# M5 Junction 10 Improvements Scheme

dDCO Change Log  
TR010063 - APP 9.21

#### Draft DCO Change Log

<b>Regulation Number:</b>	Regulation 5 (2) (b)
<b>Planning Inspectorate Scheme Reference</b>	TR010063
<b>Application Document Reference</b>	TR010063/APP/9.21
<b>Author:</b>	M5 Junction 10 Improvements Scheme Project Team

FOR CONTINUATION REFER TO SHEET 15

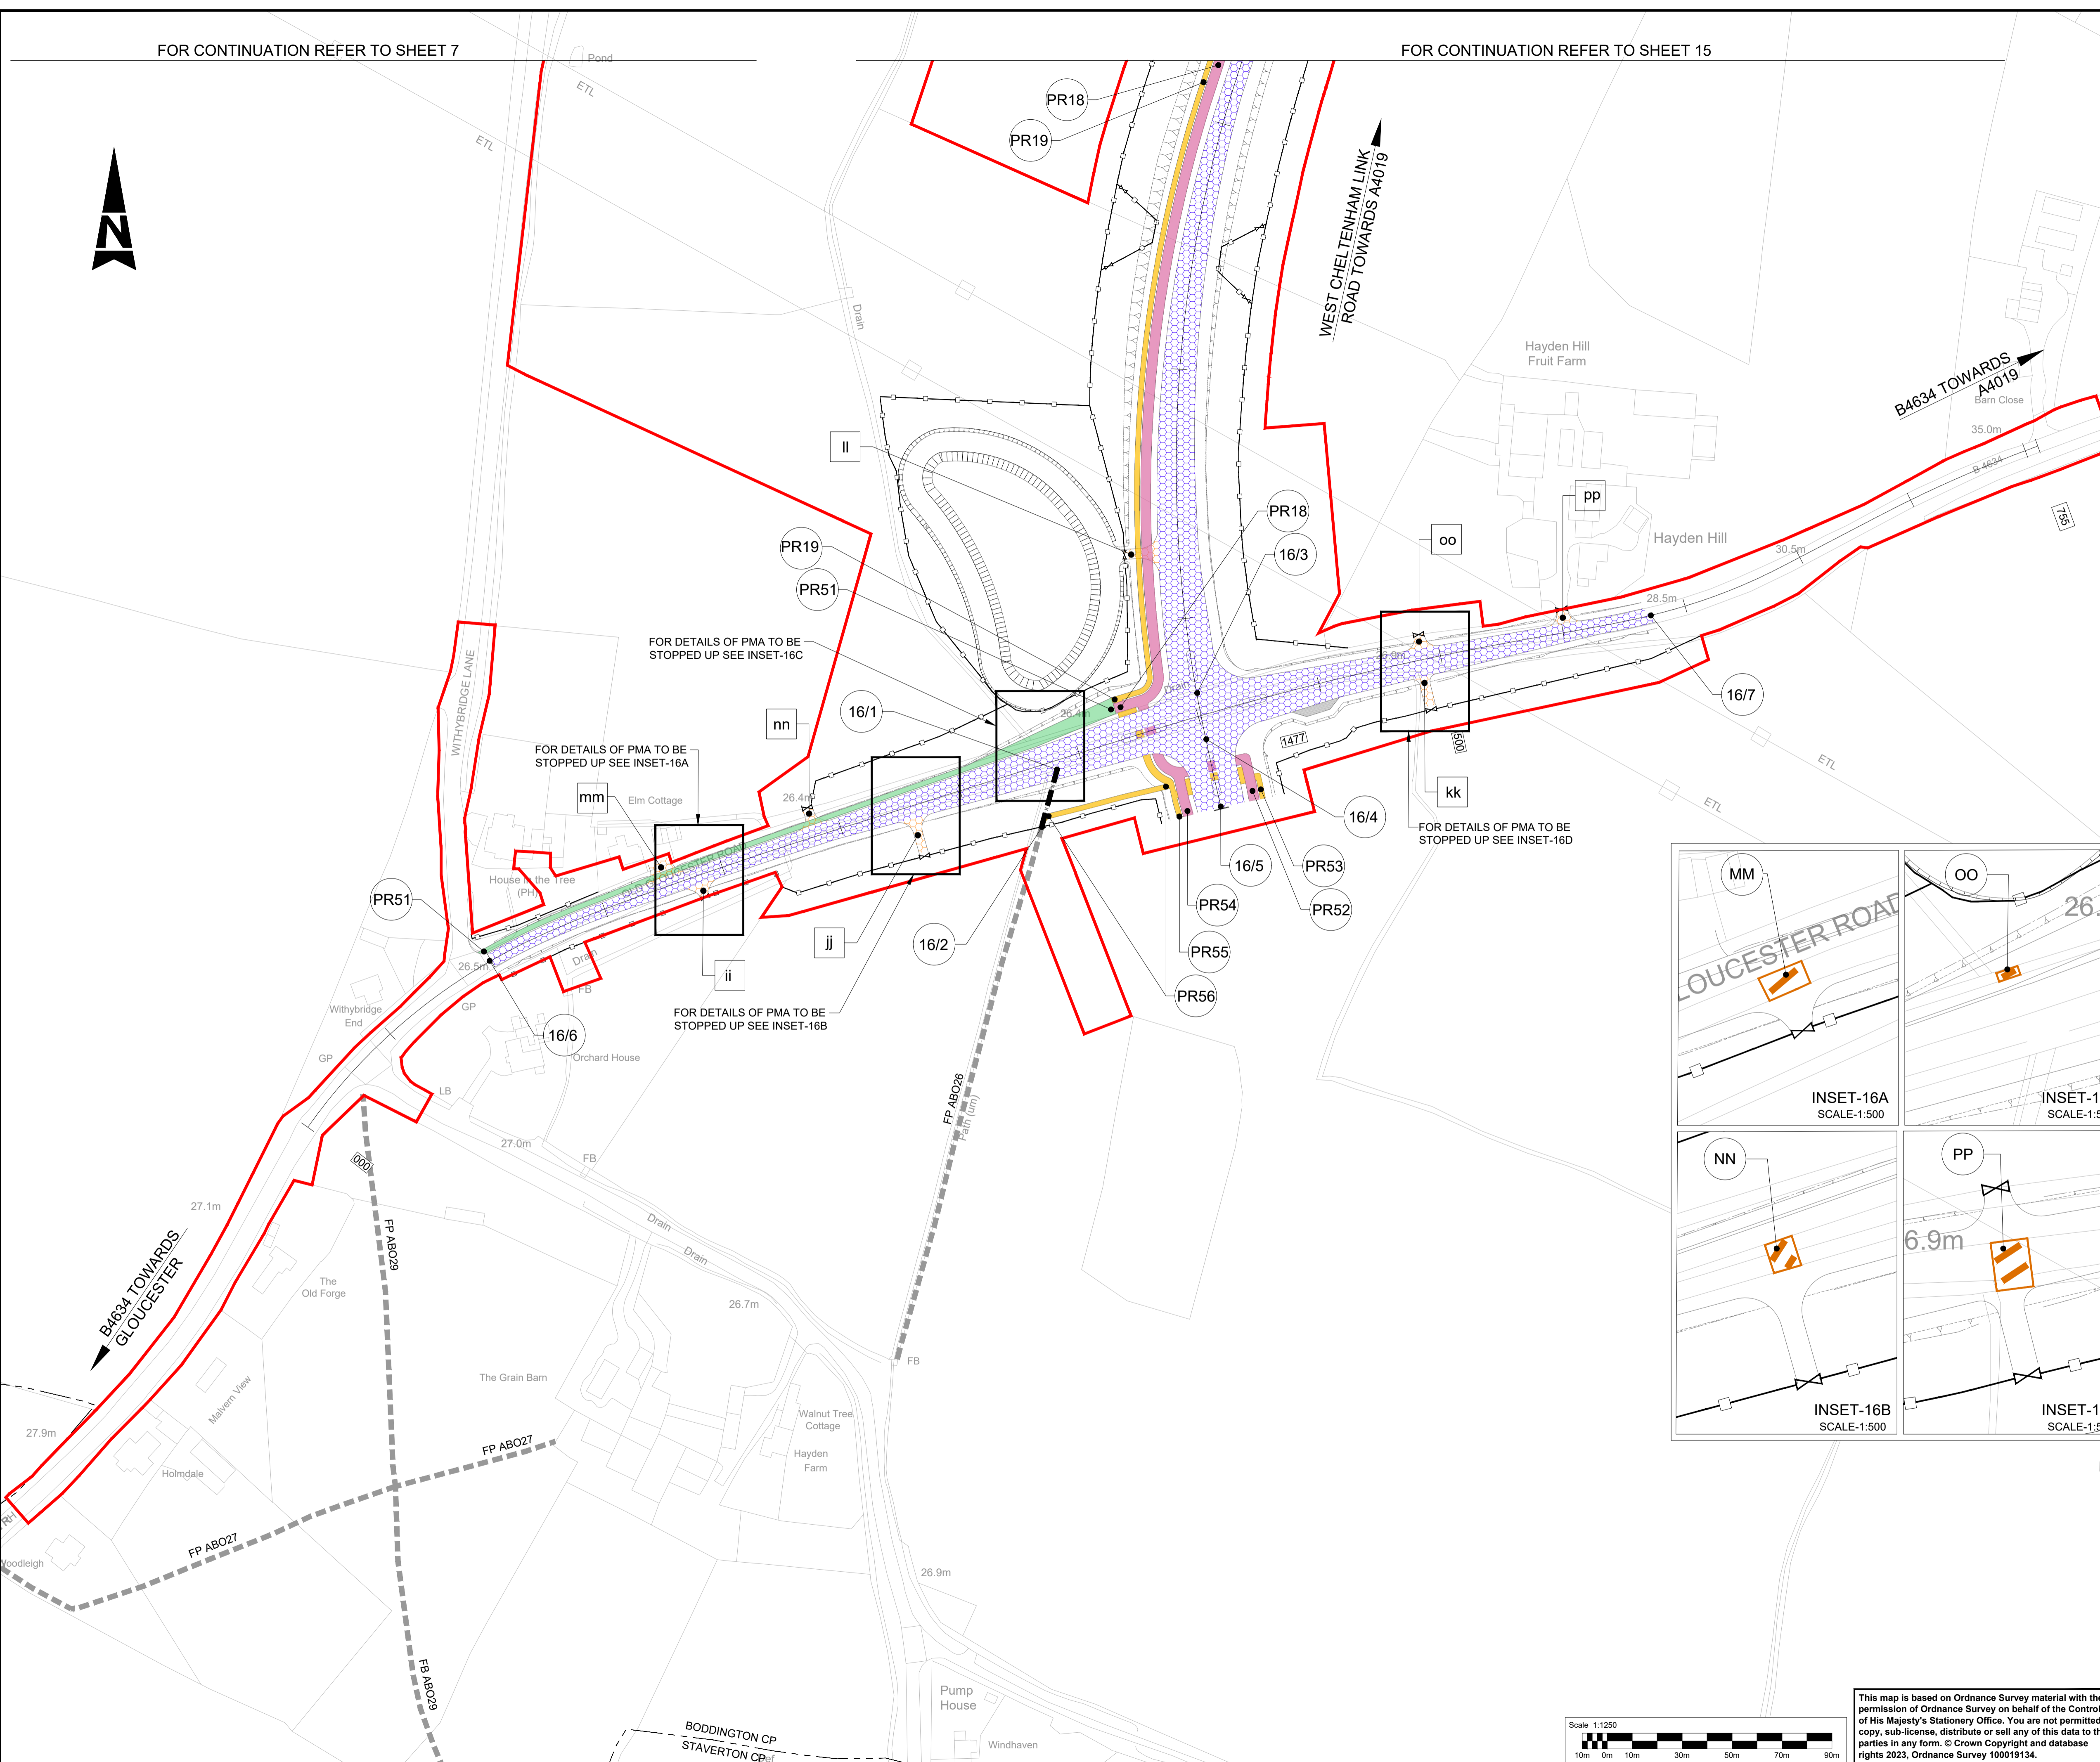
Schedule 3, Part 7	<p><u>PR49</u> <del>320-309</del> metres of footpath to the north of the River Chelt, rerouting the existing footpath ref. AUC11 under the new River Chelt Bridge, as shown on sheet 15 of the streets, rights of way and access plans</p>	To reflect changes made to the streets, rights of way and access plans which provide a minor realignment to the diverted public right of way.
Schedule 4, Part 2, Row 1	Column (3)	To reflect changes made to the streets, rights of way and access plans which provide a minor realignment to the diverted public right of way

<p>For a distance of <del>144</del><b>103</b> metres, as shown between points 15/1 and 15/2 on sheet 15 of the streets, rights of way and access plans</p> <p>Column (4)</p> <p>Reference PR49</p> <p><del>320</del><b>309</b> metres of new footpath to the north of the River Chelt, rerouting the existing footpath ref. AUC11 under the new River Chelt Bridge, as shown on sheet 15 of the streets, rights of way and access plans</p>	
Schedule 5, plot 3/2c	Removal of plot 3/2c to be inserted in Schedule 7	To align with changes to the Book of Reference, Statement of Reasons, Land Plans as a result of further engagement with National Highways.
Schedule 5, plot 4/1c	<p>New plot added to schedule which had been permanent acquisition. New rights required for work numbers 1a, 1c, 1e, 1n being:</p> <p><u><a href="#">New right for the construction of motorway signage and associated cabling and ducting works</a></u></p> <p><u><a href="#">New right for the construction of a new southbound exit slip from the M5 to the A4019</a></u></p> <p><u><a href="#">New right for the construction of a new northbound entry slip from the A4019 to the M5</a></u></p> <p><u><a href="#">New right for the construction of an environmental barrier adjacent to Barn Farm north of Junction 10 and west of the M5</a></u></p>	To align with changes to the Book of Reference, Statement of Reasons, Land Plans as a result of further engagement with National Highways.
